Please ask for: Ms Iqraa Malik  
Email: [iqraa.malik@terraquest.co.uk](mailto:iqraa.malik@terraquest.co.uk)  
Telephone: 01212341390  
Our Ref: FP/109/21/HH  
Your Ref:  
Date: 12th May 2021

**Application for Planning Permission for Works or Extension to a Dwelling**

**Development:** Change of main roof design from hipped roof to gable end roof, a change in design front dormer and front porch to provide pitched roof and a two storey rear extension.  
**Location:** 24 New Barn Lane Felpham PO22 8LN

Proposed Front and Rear Extension Plans and Elevations
Planning
Date May 2021
Scale 1:50

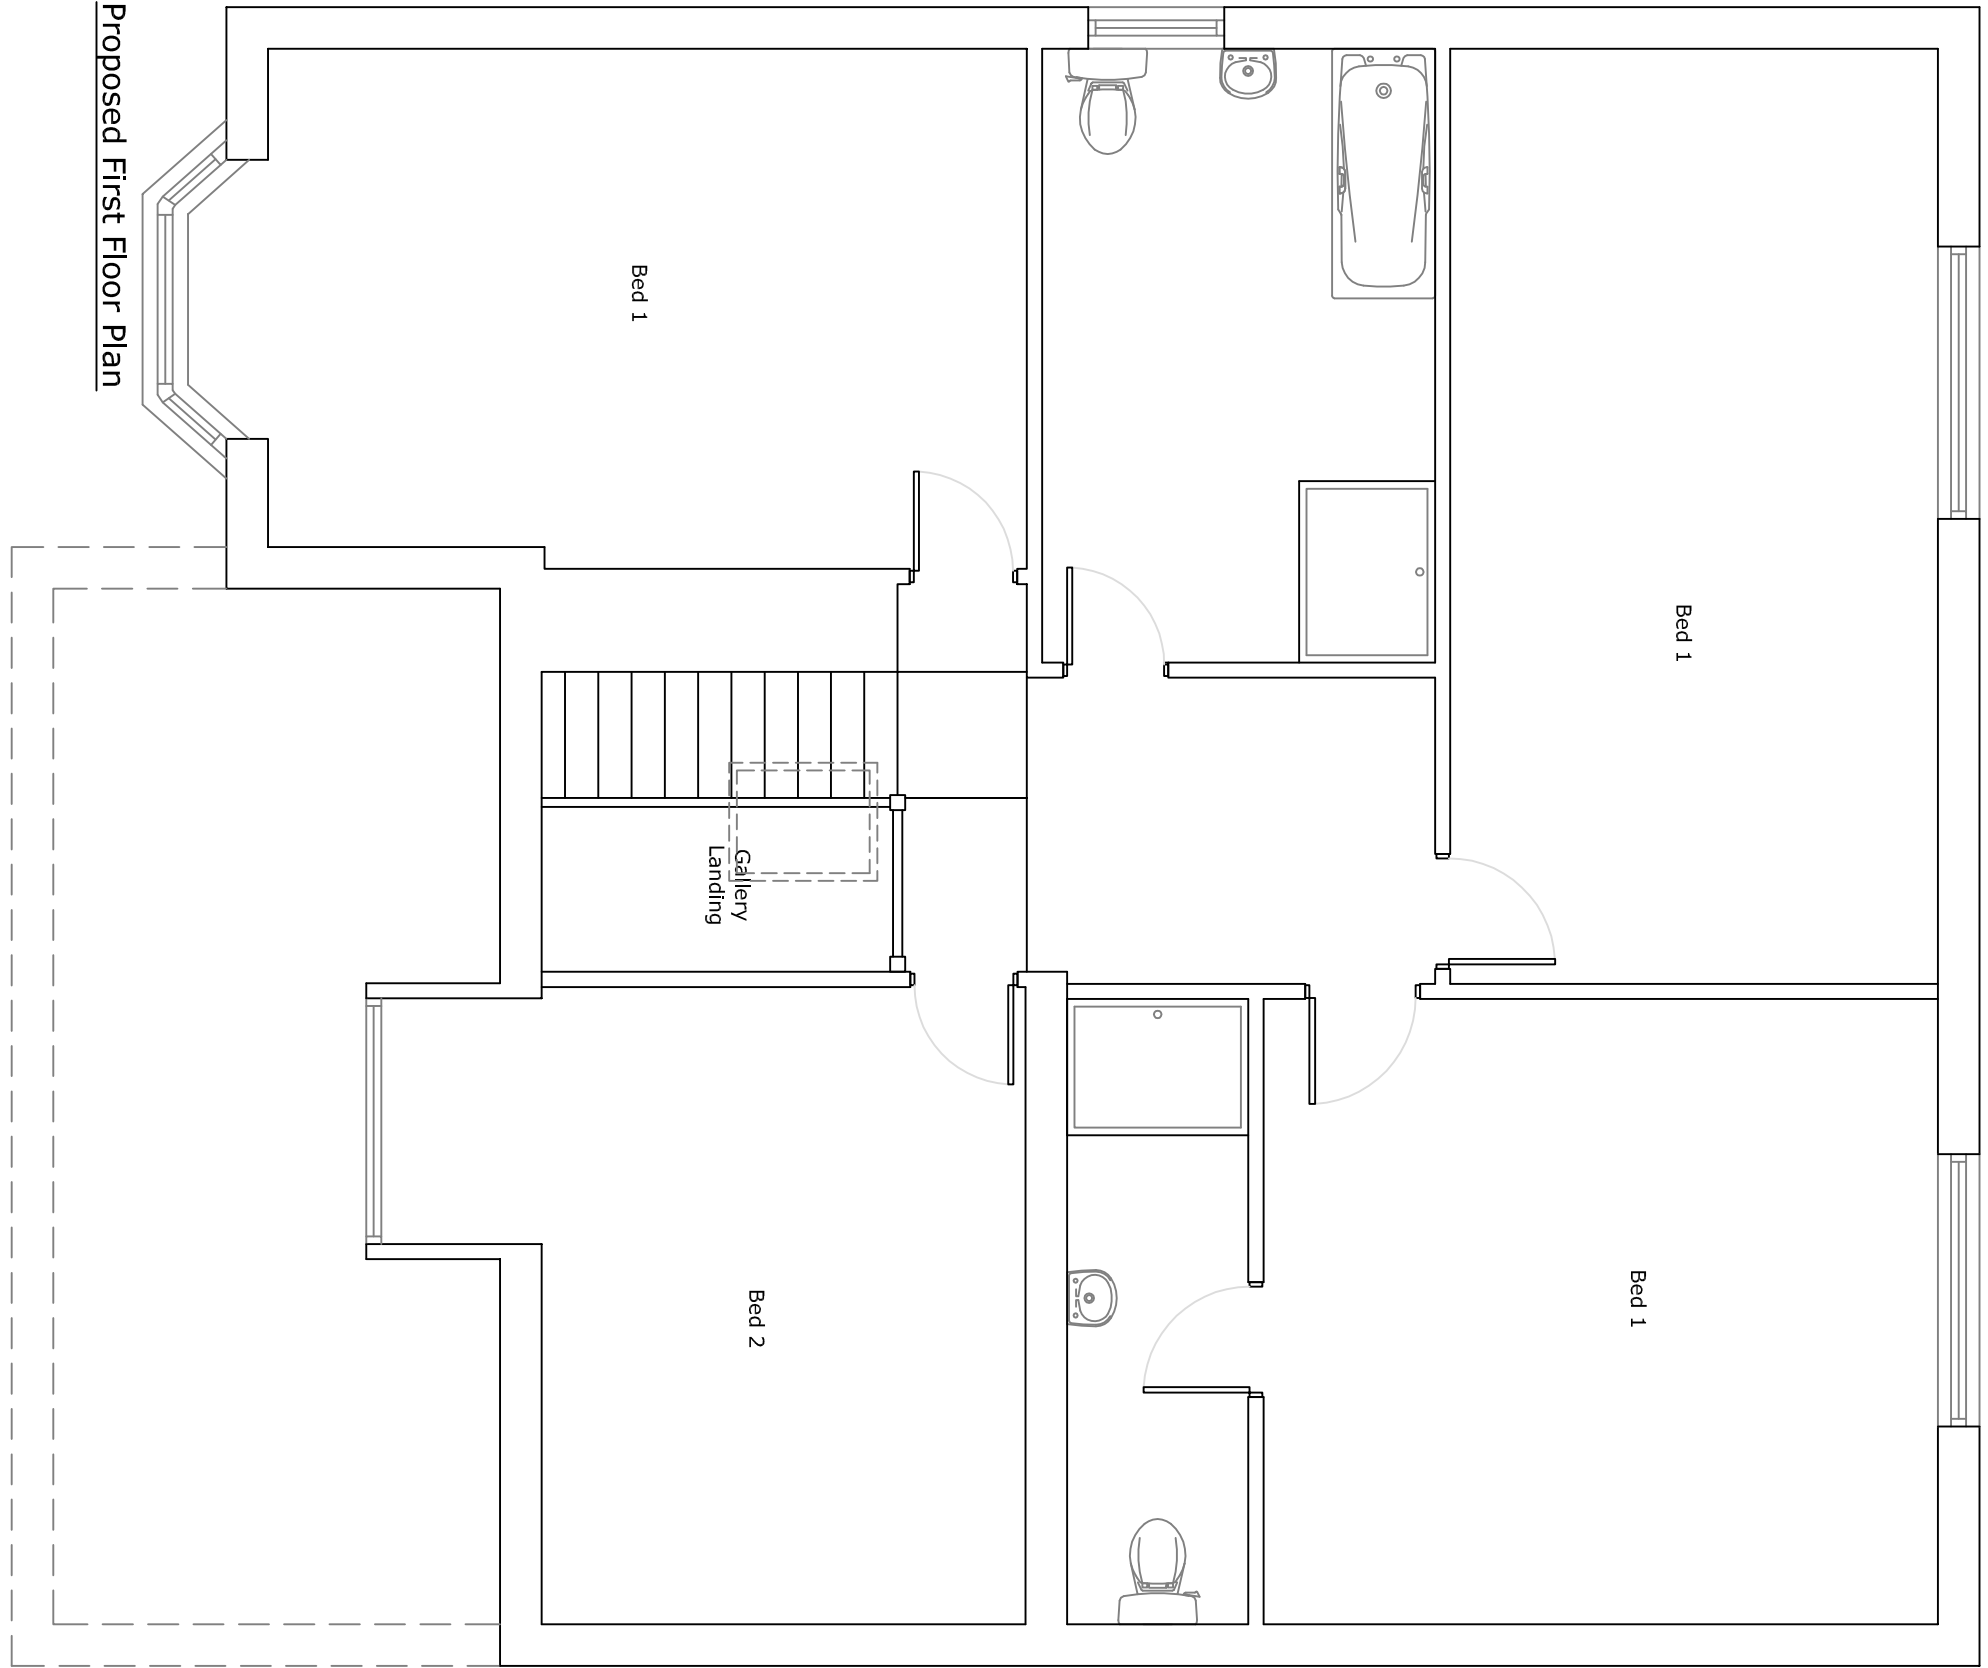
**Block Plan**

Please include all proposed works on the block plan, the front extension is missing. Please include this along with the dimensions to the site boundaries.
